Town & Country Planning Act 1990 (as amended)
Town and Country Planning (Development Management Procedure) (England) Order 2015
Application for approval of details reserved by condition imposed on planning ref FG/105/18/PL
relating to conditions 4 (Surface water drainage), 6 (Risk of contamination), 10 (Construction
management plan) & 13 (Surface water drainage)
Land at Asda Superstore Littlehampton Road, Ferring Worthing,

Arun District Council have decided to **REFUSE details reserved by condition for the following reasons:**

Title
Proposed Drainage Details

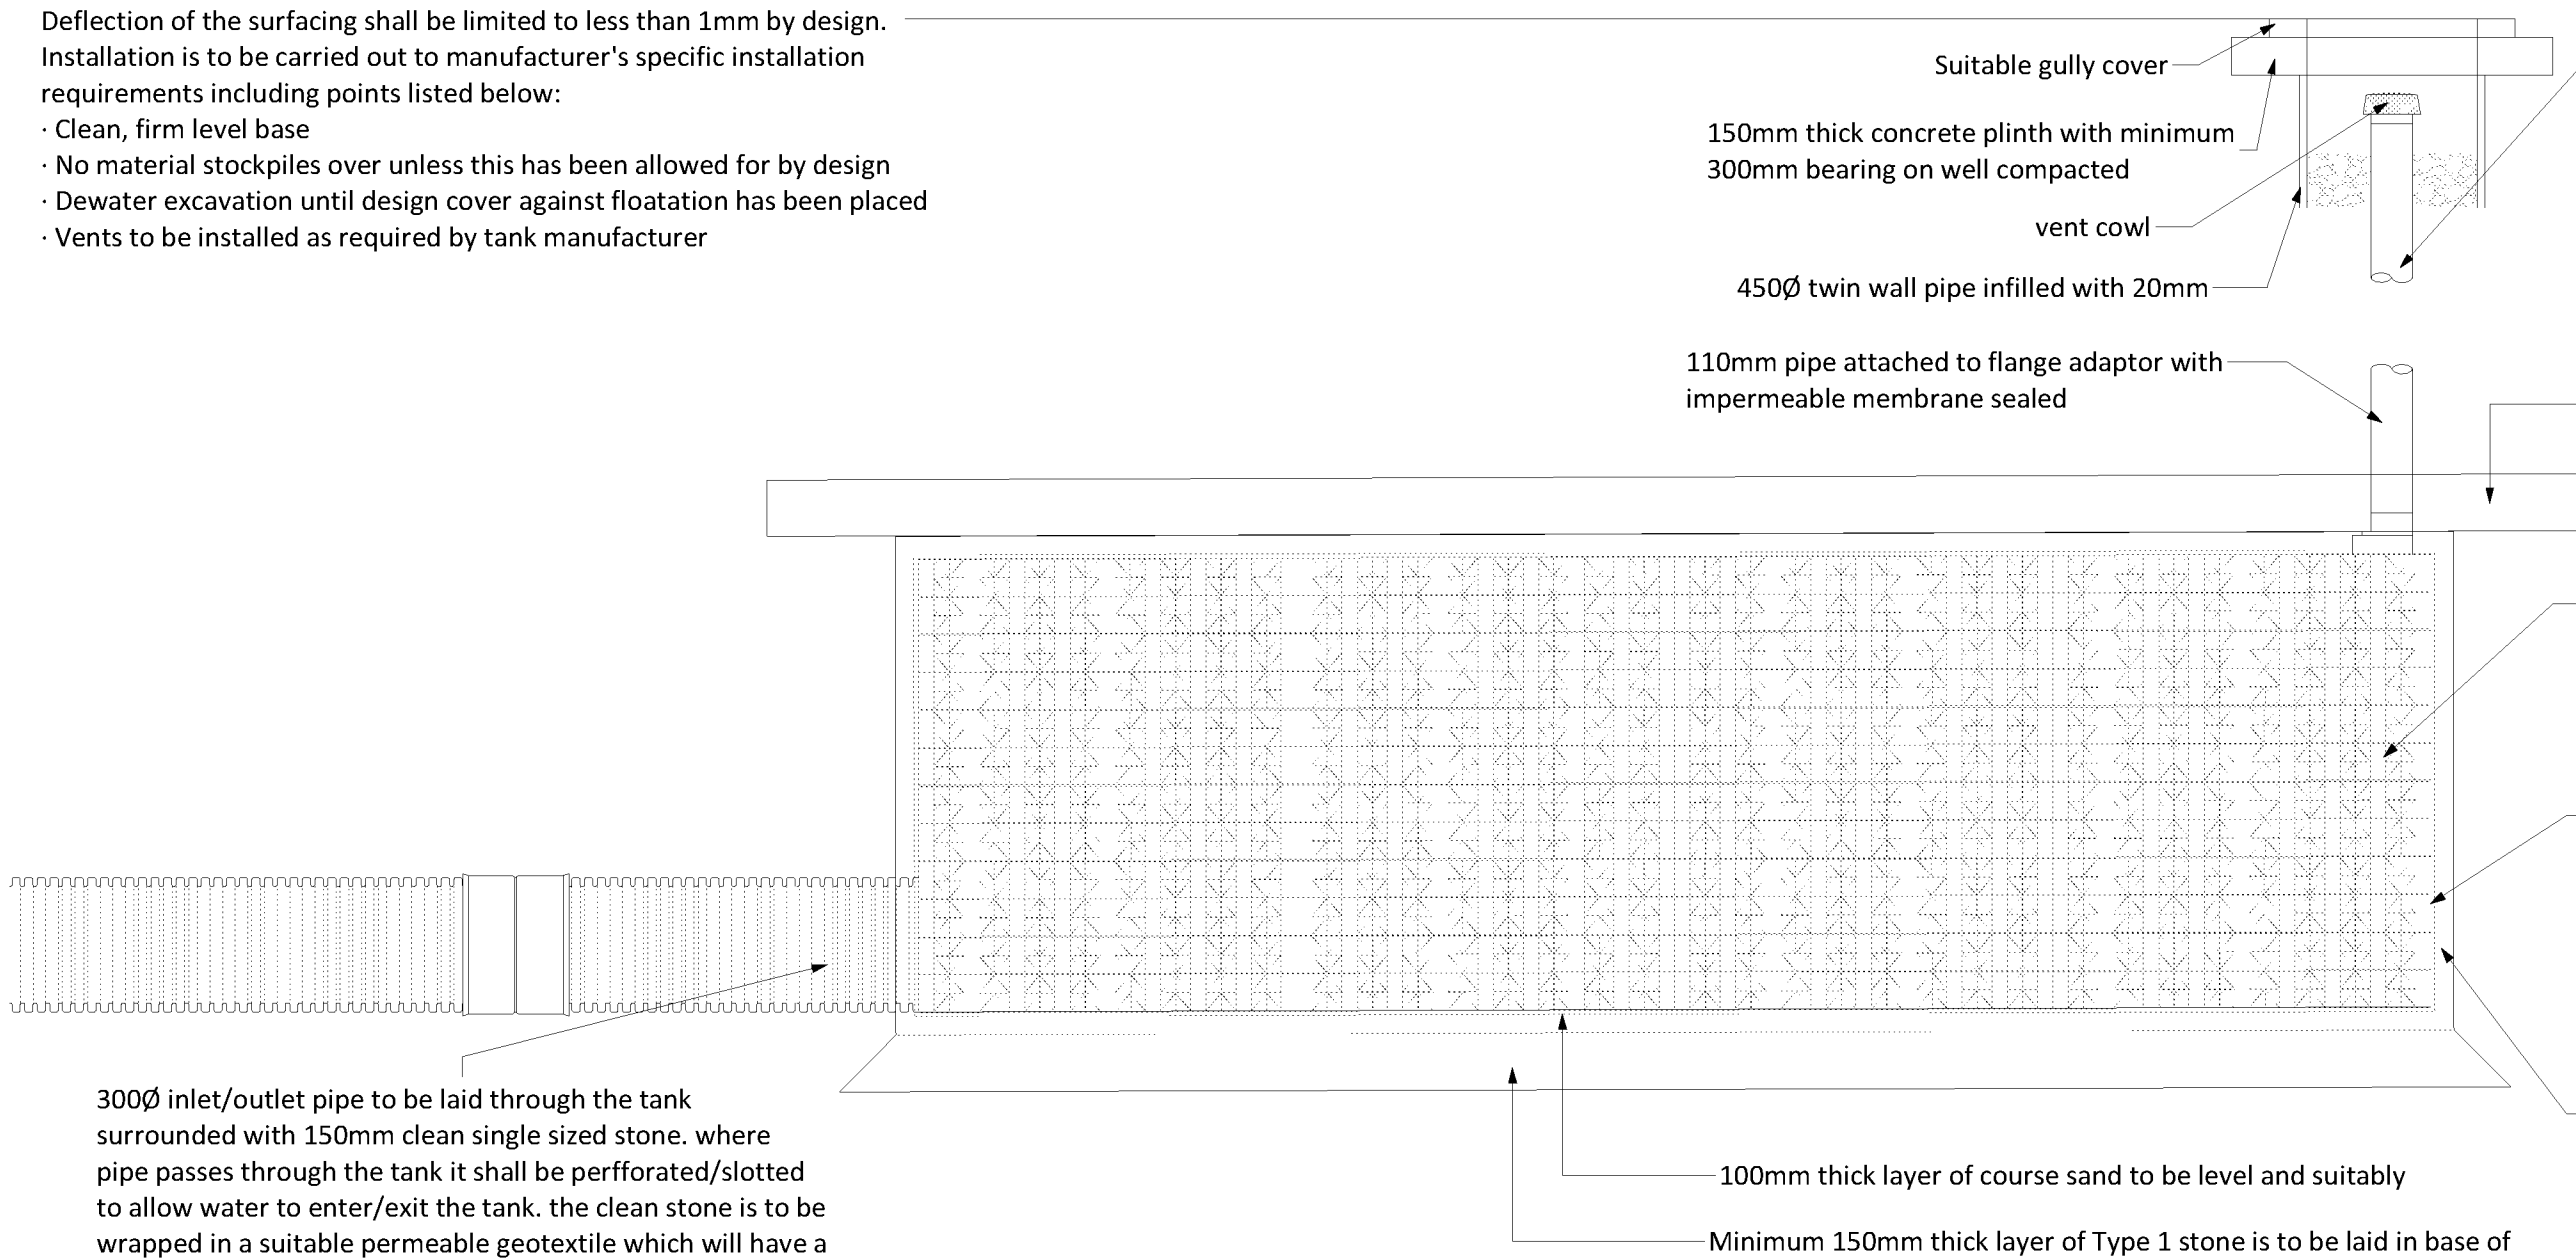
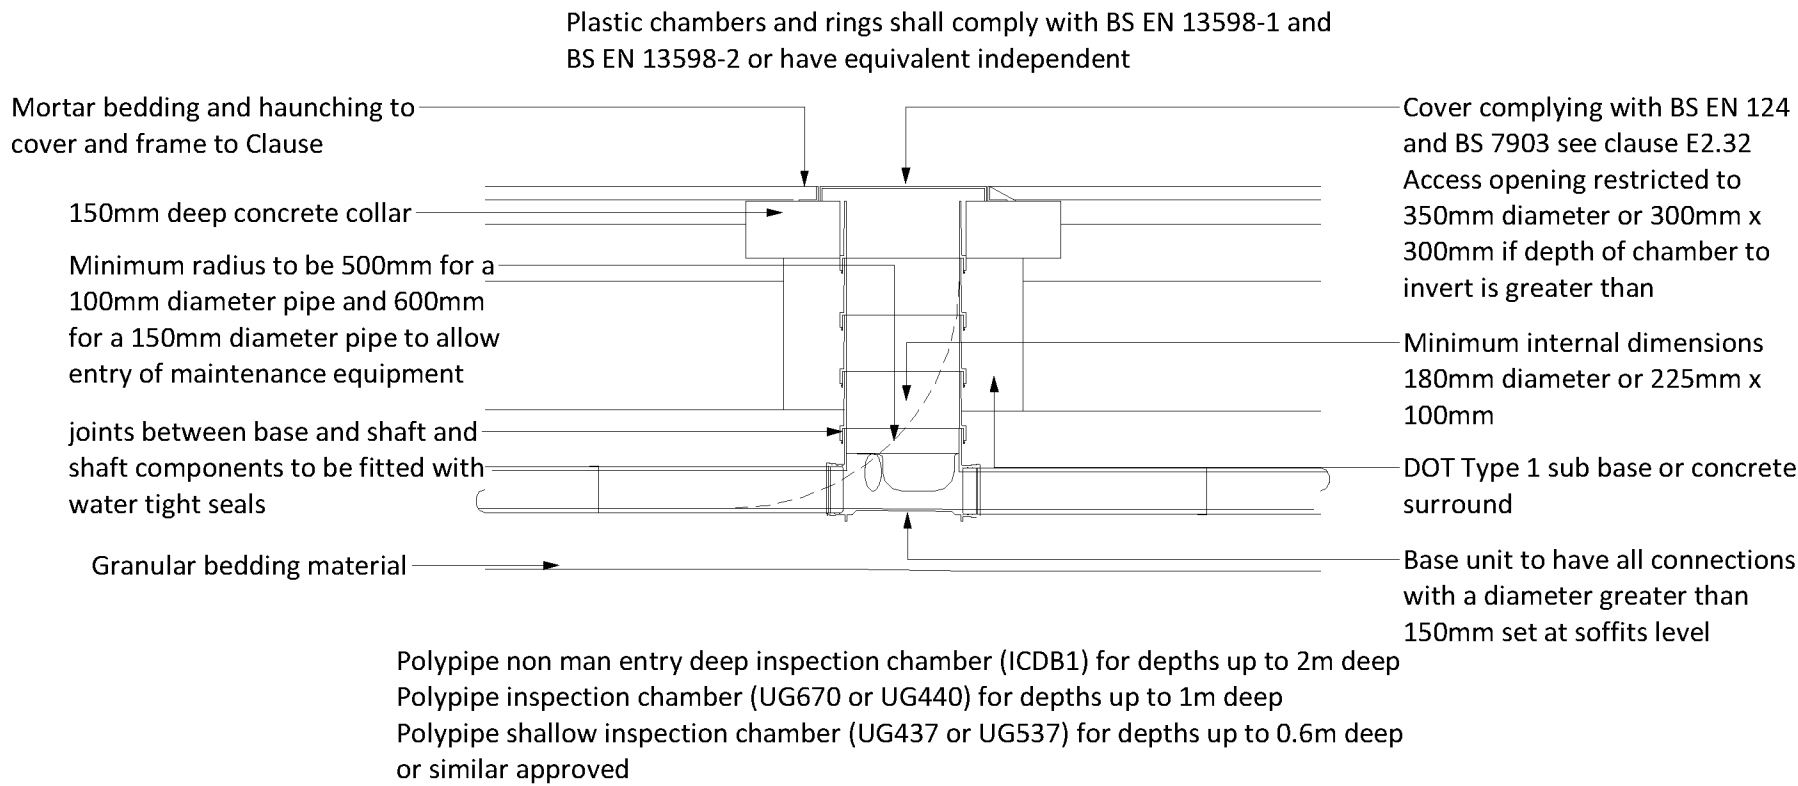
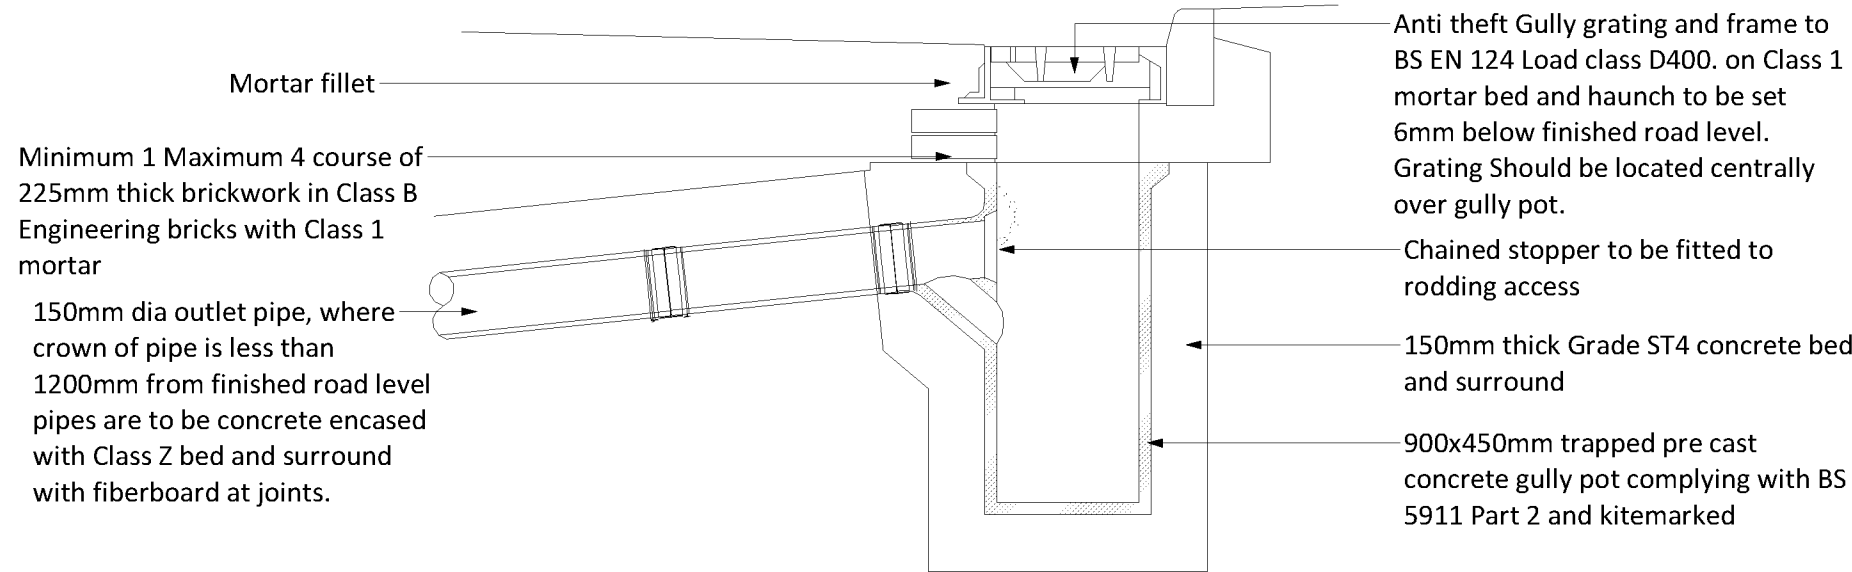
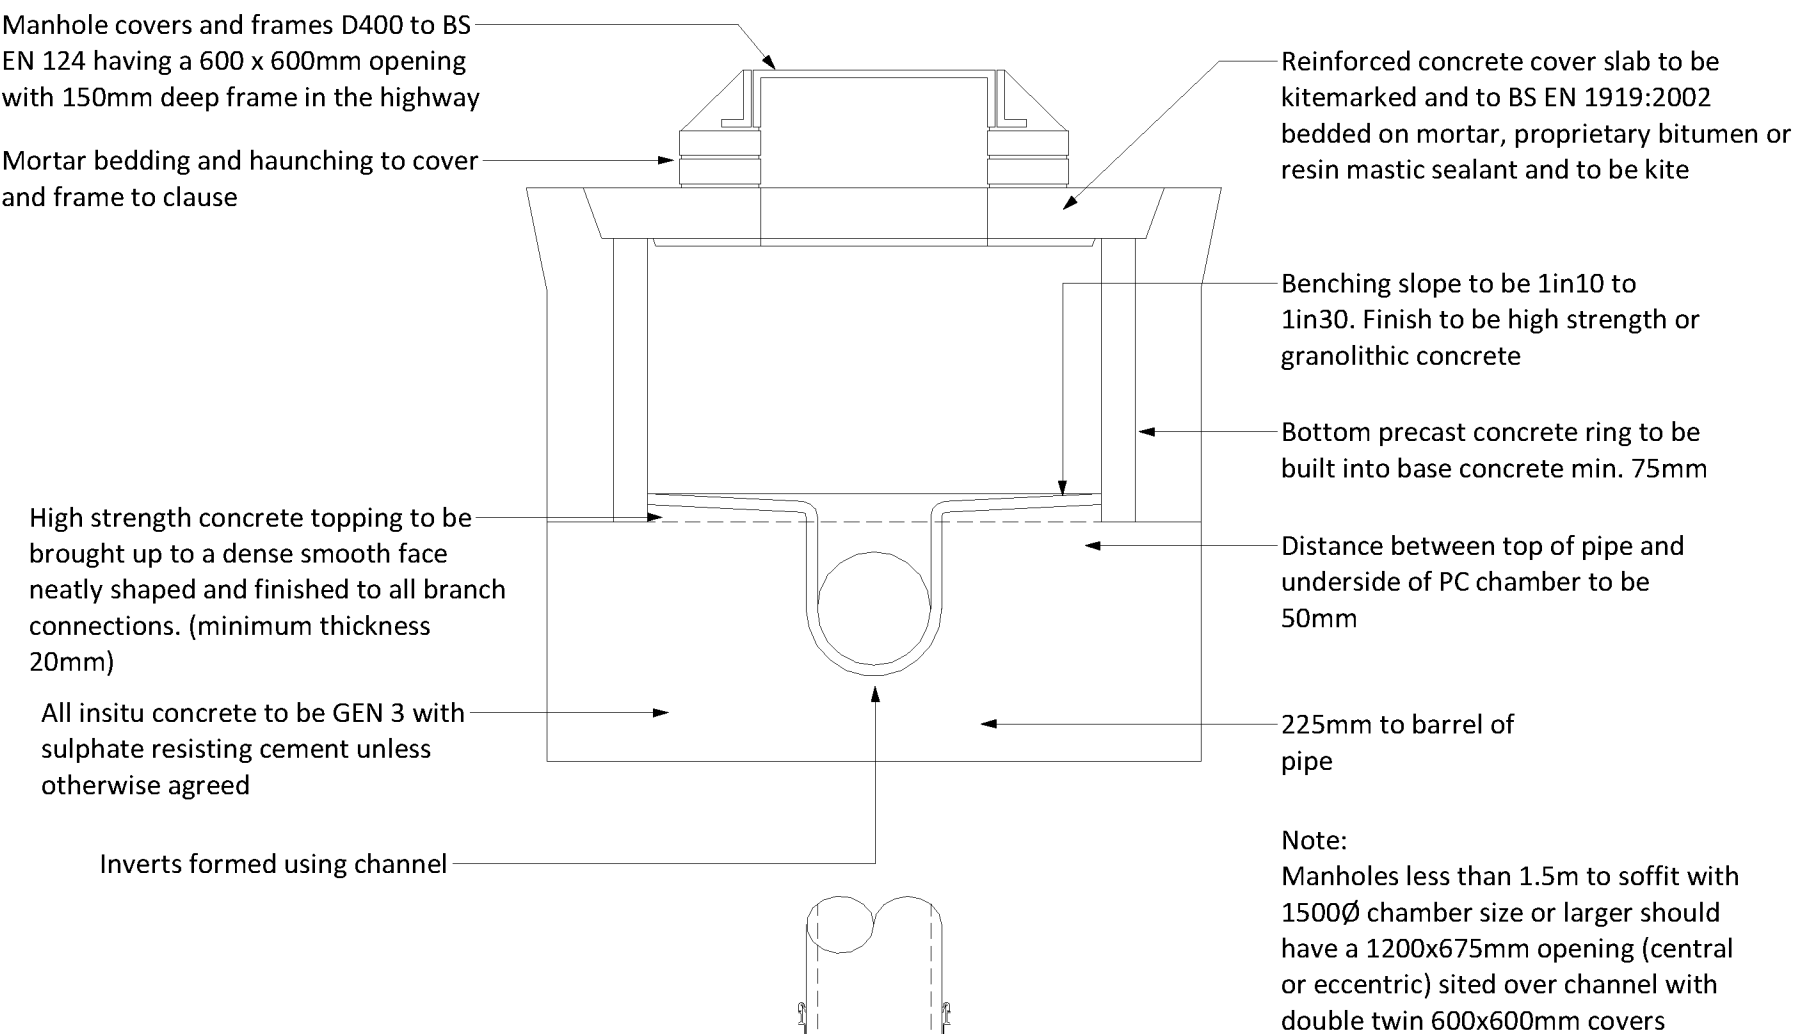
This condition cannot be discharged at this stage. Our Engineer is keen to see an increase in storage area rather than just changing the inputs in the calculations.

She is also concerned regarding the hydrobrake and all of the uncertainty regarding it, and the fact that things are being changed within the simulations. The reality is that it is fixed and it is not known what it is. It is suggested that you consider providing a manhole and hydrobrake upstream of this, which would be constructed in line with what is provided in the calculations. This would seem to be the only way to guarantee the system will function as intended.

Some flooding of the access road to ASDA currently occurs. This area is utilising the existing hydrobrake, it can be taken that either gullies were blocked or there is insufficient capacity within the existing system. Therefore, adding further weight to the argument of restricting flow before it reaches the existing hydrobrake.
